Steeple_ISH_12 NOV_PT3

FULL TRANSCRIPT (with timecode)

Okay, I'm seeing agreement. Is there anyone online as well who has any comments? If they're happy with working through until 5:00, I'm not seeing any objections, so we'll continue then. Um, so I just want to talk now through the findings of some of the visual effects. Um, and I'm going to focus on the Trend Valley Way. At Fenton Lane is the one example I'm going to to use today.

VIEWPOINT 12B

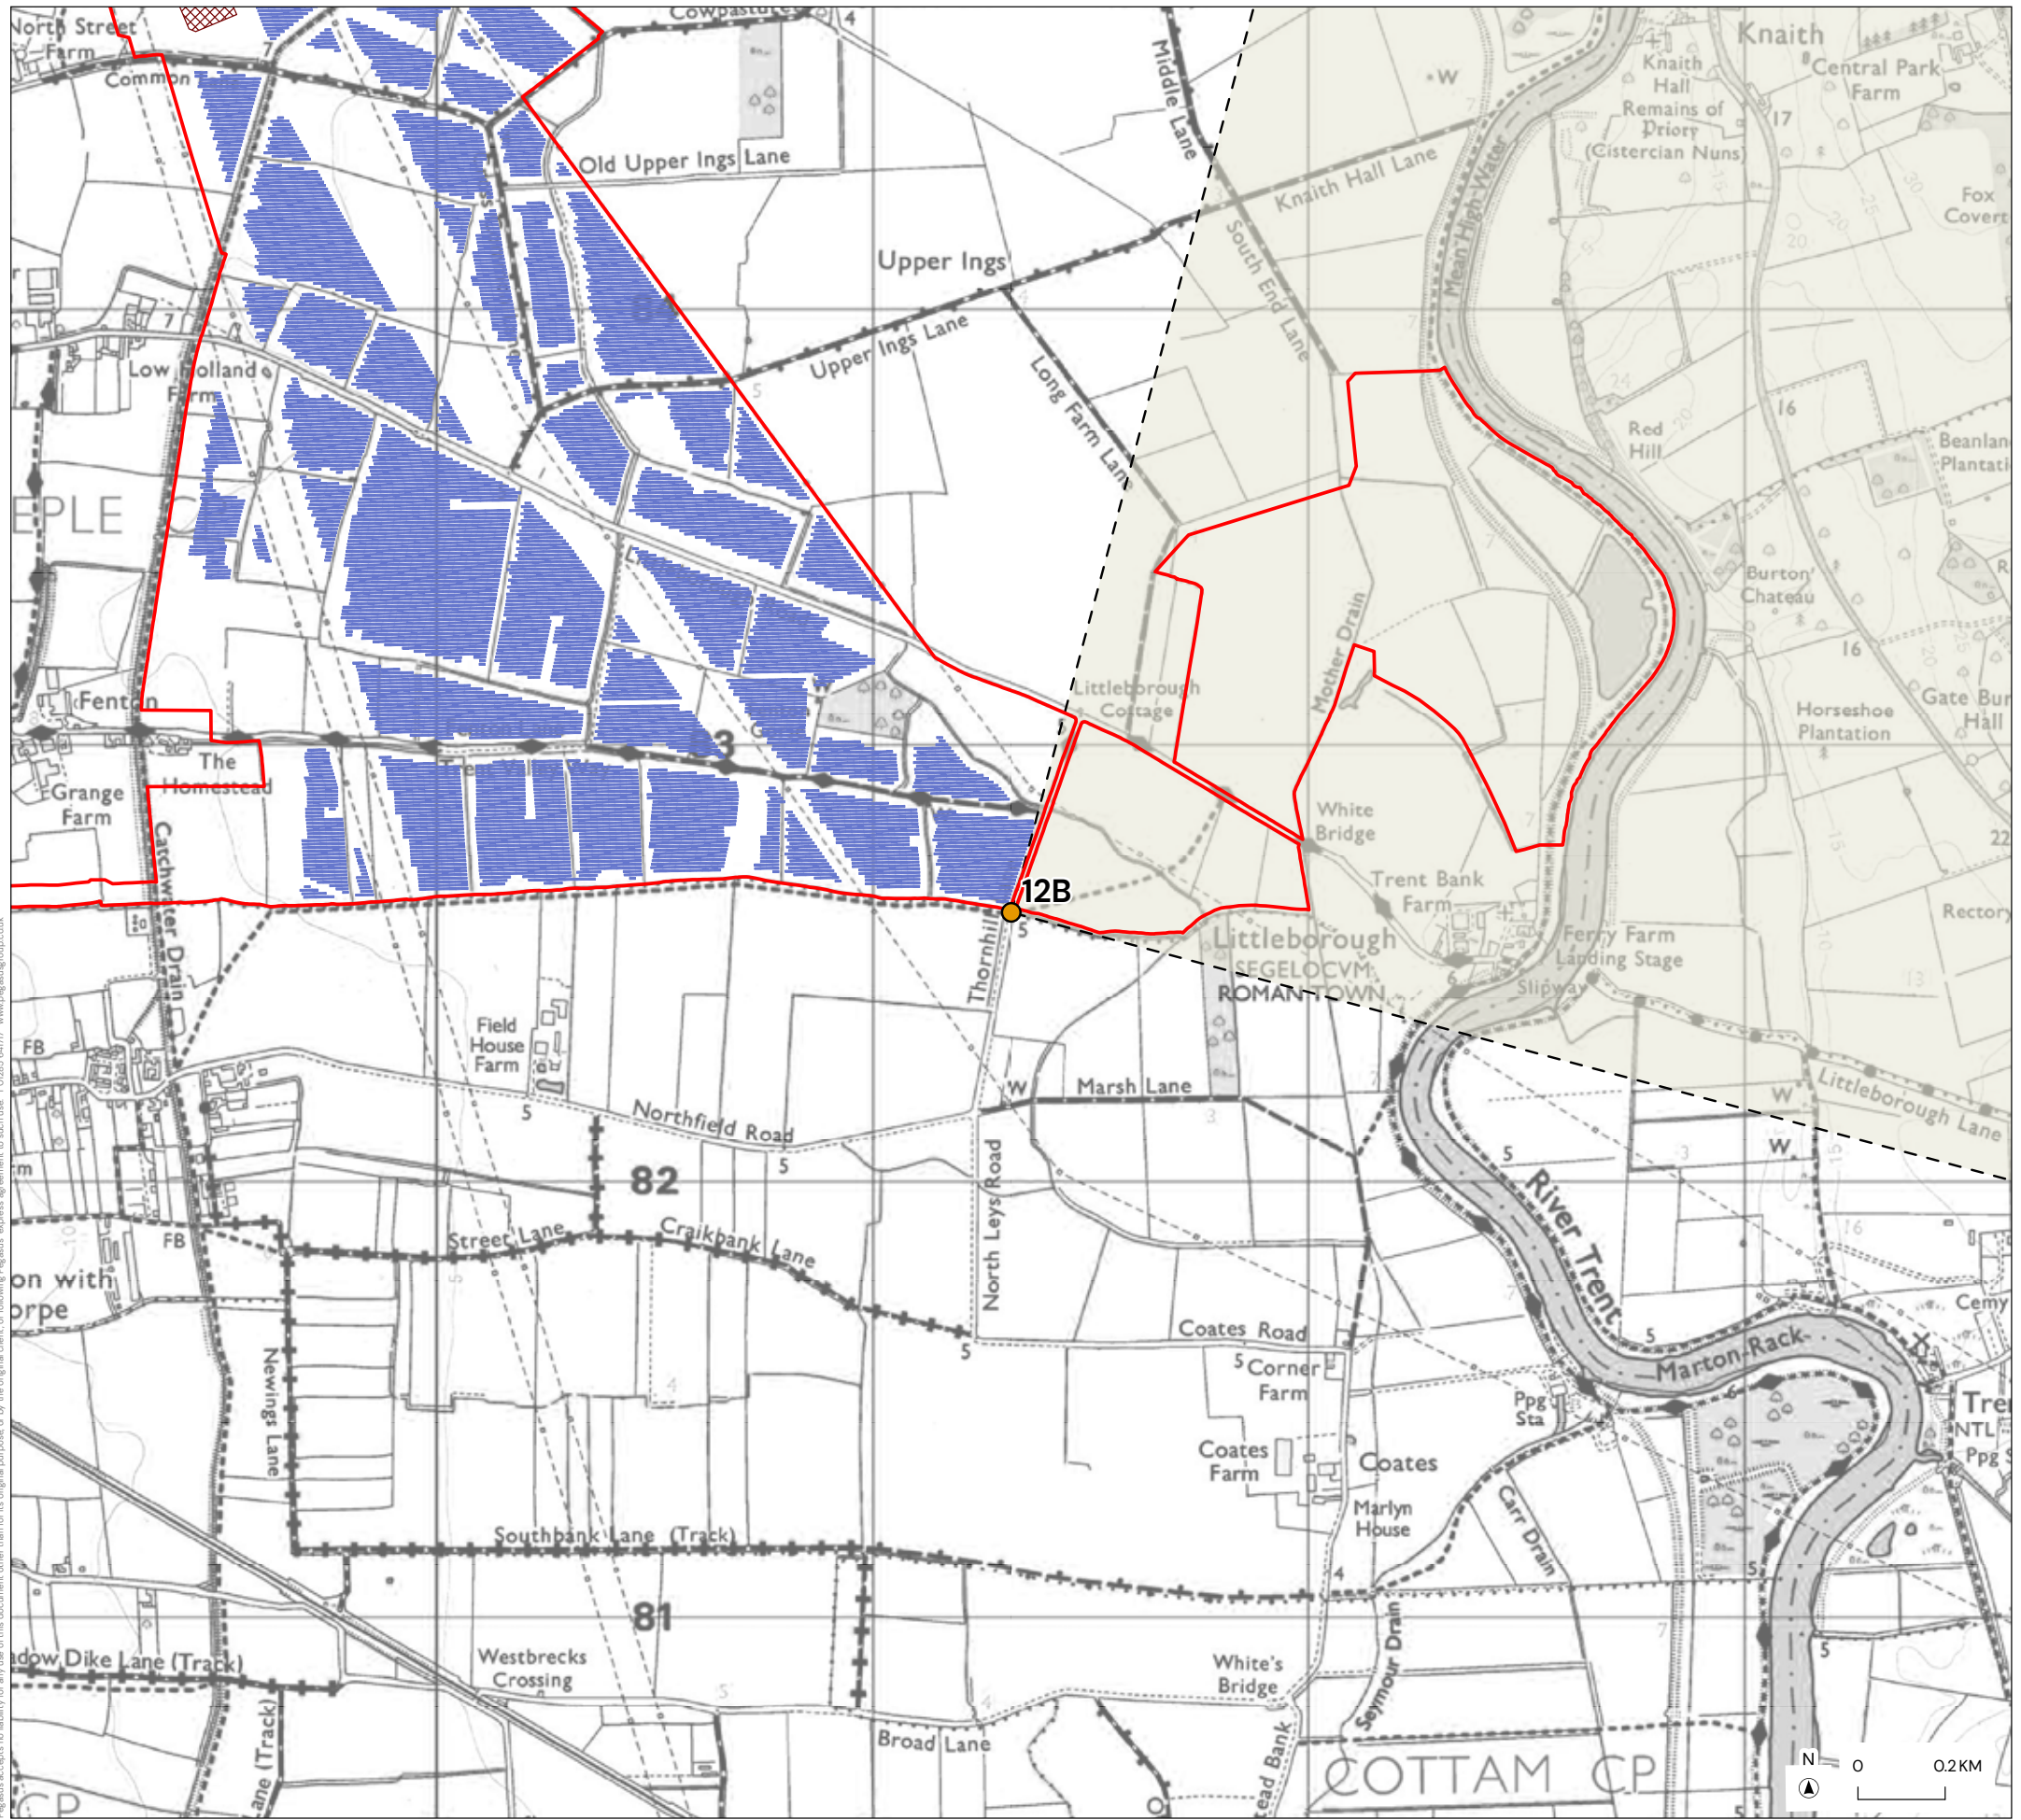
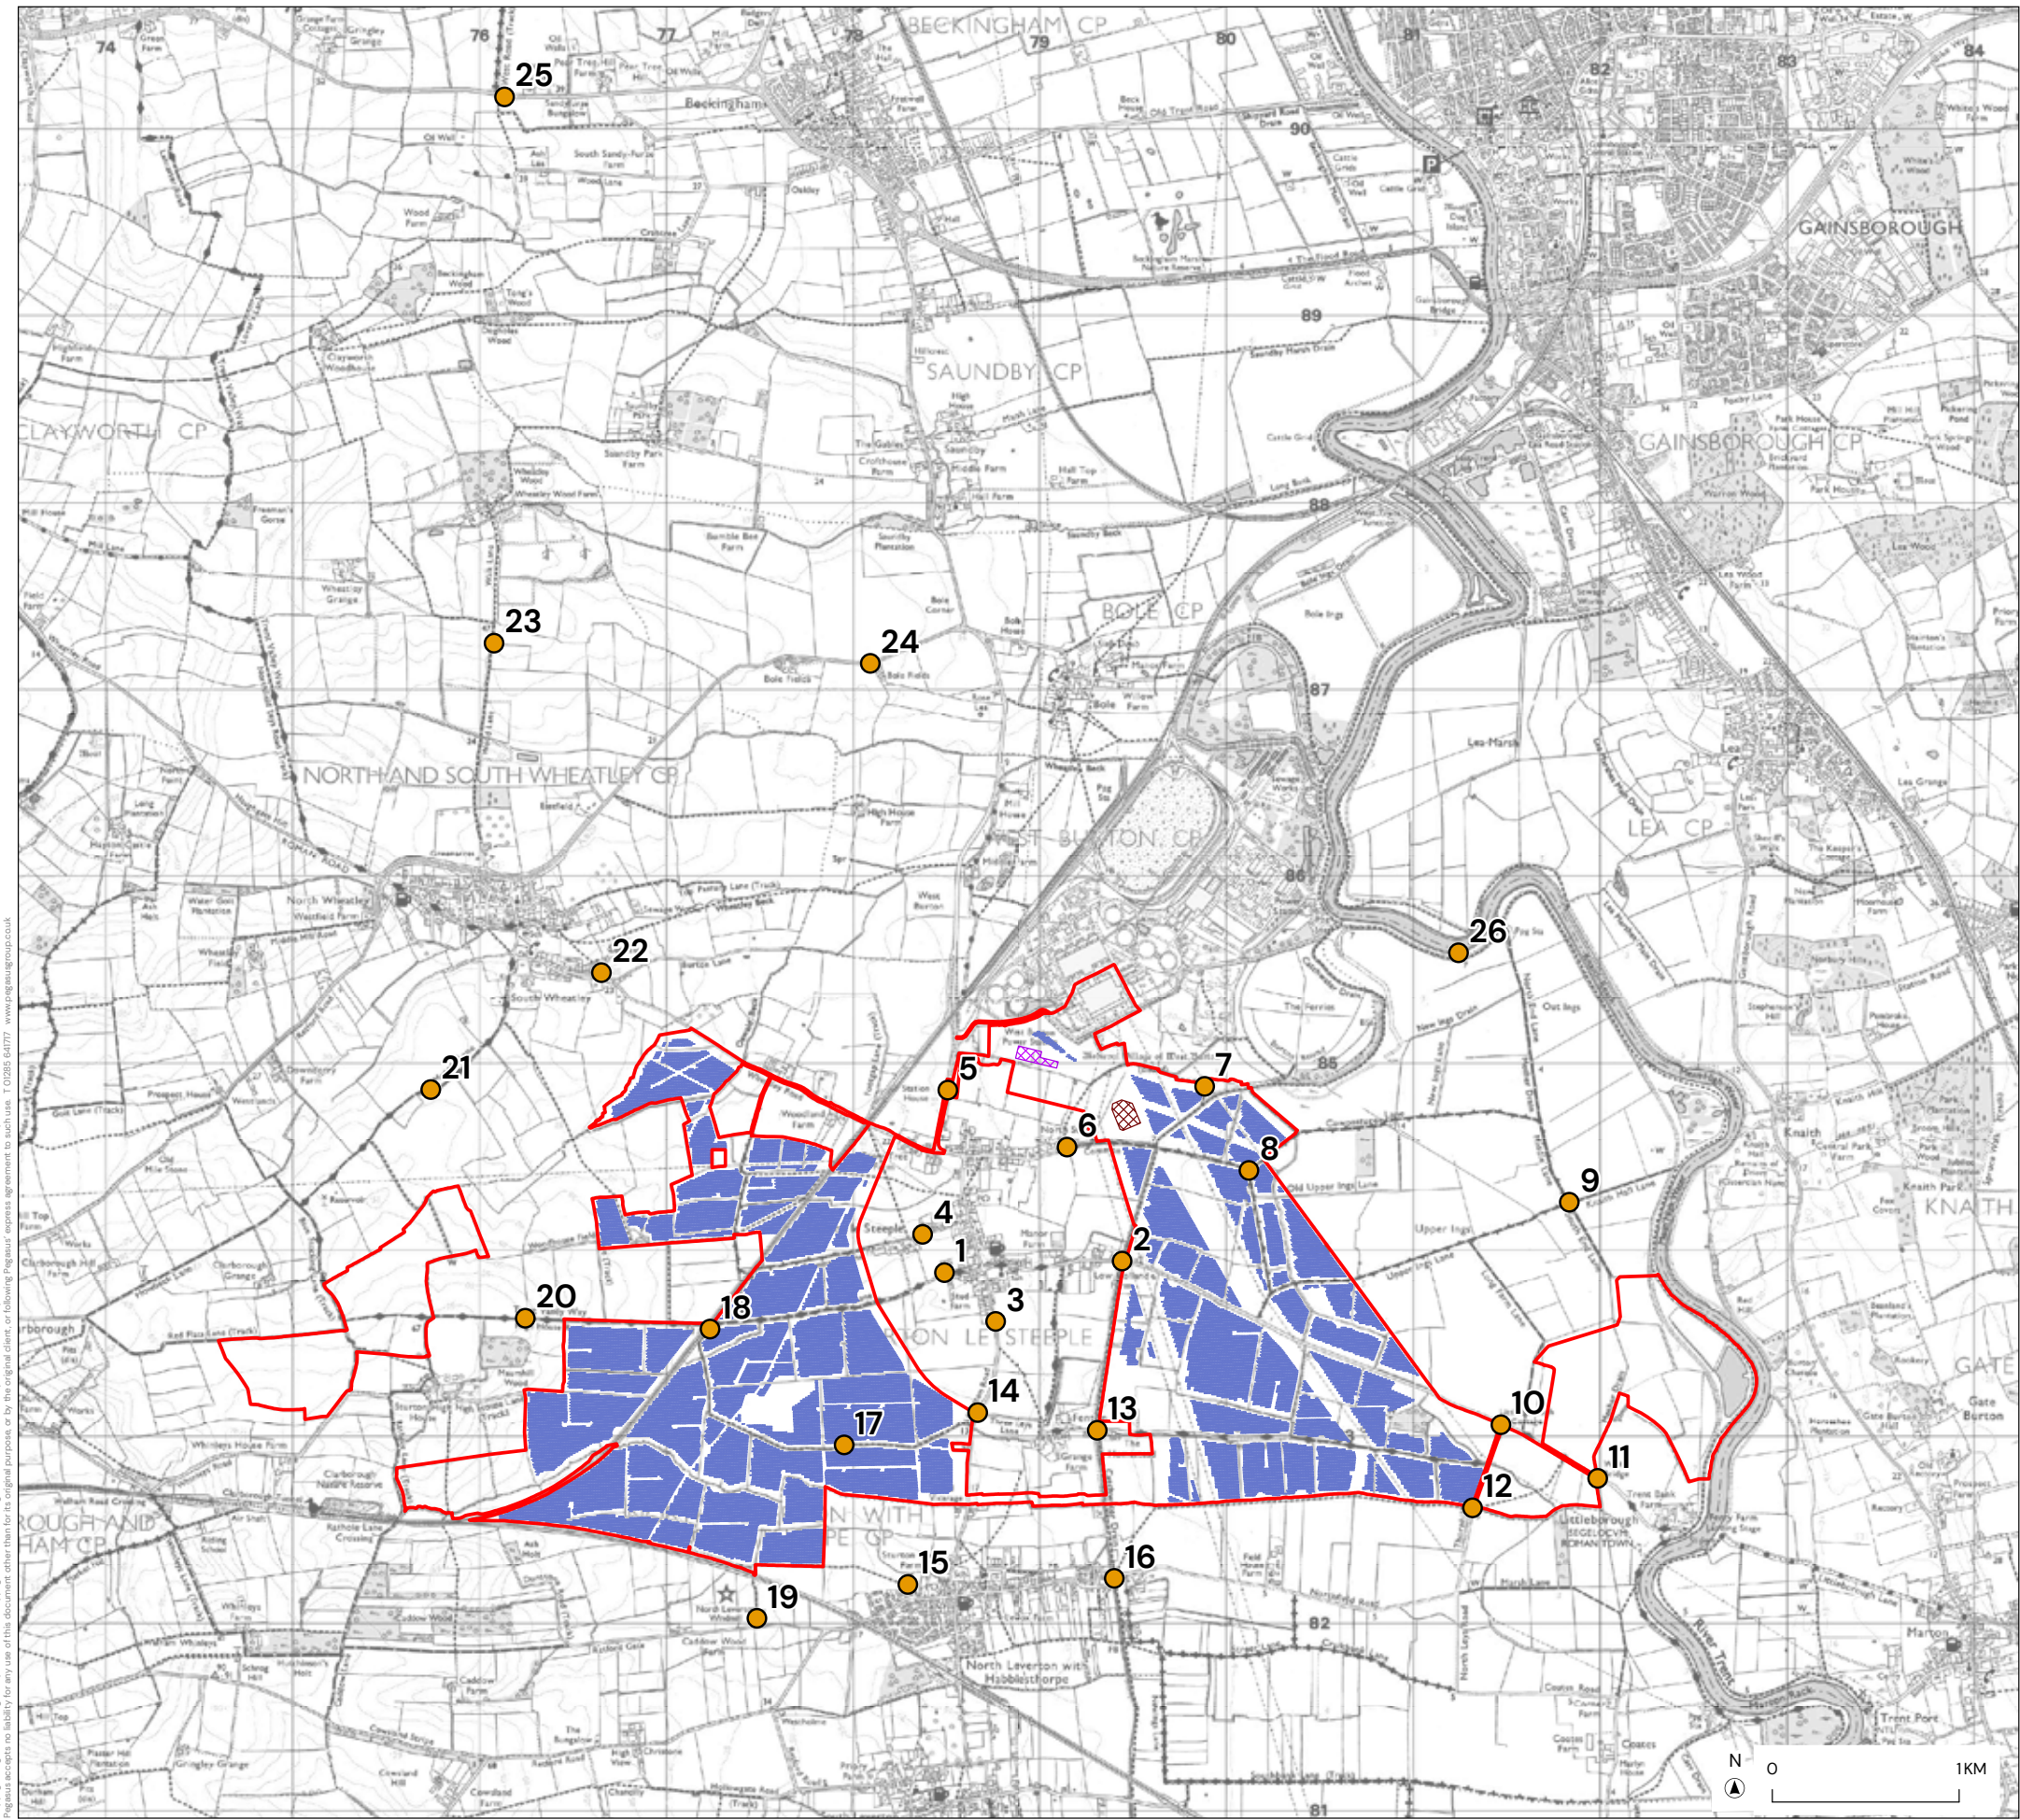
Okay. I think, um, just to help a discussion here, I'm just going to ask you to display a view .12. Um, which is the only sort of viewpoint that I can really see that might help. It's not along this route, um, in particular, but it is at the end of it. So if you can display photo montage viewpoint 12.

Okay, I can see it successfully screens the panels. I can I can understand where you're coming from and that I just wouldn't mind a little bit more of how it is considered a beneficial effect in comparison to what we saw in the baseline in more on the on the the open landscape view that you saw in the baseline photograph. And I appreciate that you've got the the power station in the distance. But just explain to me again, just the thought process of why that is the beneficial effect in that particular viewpoint.

But I think the, uh, the graphic in front of us, year of year 15, um, is possibly a bit misleading because it doesn't look like the hedgerow has been well maintained. Um, and I suspect, I suspect if it was, if it was maintained like that, that you would actually be able to see through the hedgerow. Um, it wouldn't be dense enough to to actually prevent you from at least getting a glimpse. Partial views of the panels through the vegetation, especially in winter.

Yeah. So what's on the screen at the moment is the is the baseline photograph, as you alluded to. And it's um, illustrating the location at one of our viewpoints, which is at the junction of a public footpath and a minor road. Um current view includes um, sort of flat, open landscape views towards the power station site and, and the pylons and sort of functional use for, for agriculture. Um, and then as we move to the year one image, uh, we see the development, uh, so the fence in the foreground and, and the panels beyond.

Yeah. So at this point at year 15, you can see the, uh, the hedgerow, um, in winter growth, uh, with 15 years of growth, um, successfully screening the panels. Um, and although this particular angle is orientated directly towards the site, you can see towards the left of the image. Um, part of the corridor I was describing there, which would remain, remain open and would have no no views of the panels as a result of the success of the planting.

To be clear, we haven't identified it as a beneficial effect. We've identified it as an adverse effect, but one which wasn't significant by year 15.

Correct. That is correct. Yes. So, um, we concede it as an adverse change, but not a significant one because of the fact you don't see the panels and you would have that corridor maintained.

Just with respect to the, um, the visualization there. Um, the planting would be managed both for landscape and visual and biodiversity purposes. Um, and so the growth would be, uh, managed to encourage both, uh, screening benefit but also uh, biodiversity benefits as well. So there would be a degree of, of cutting and management to ensure the growth was strong. And you could get the screening benefit, but there would also be consideration given to maximizing the biodiversity benefits through that management regime as well.
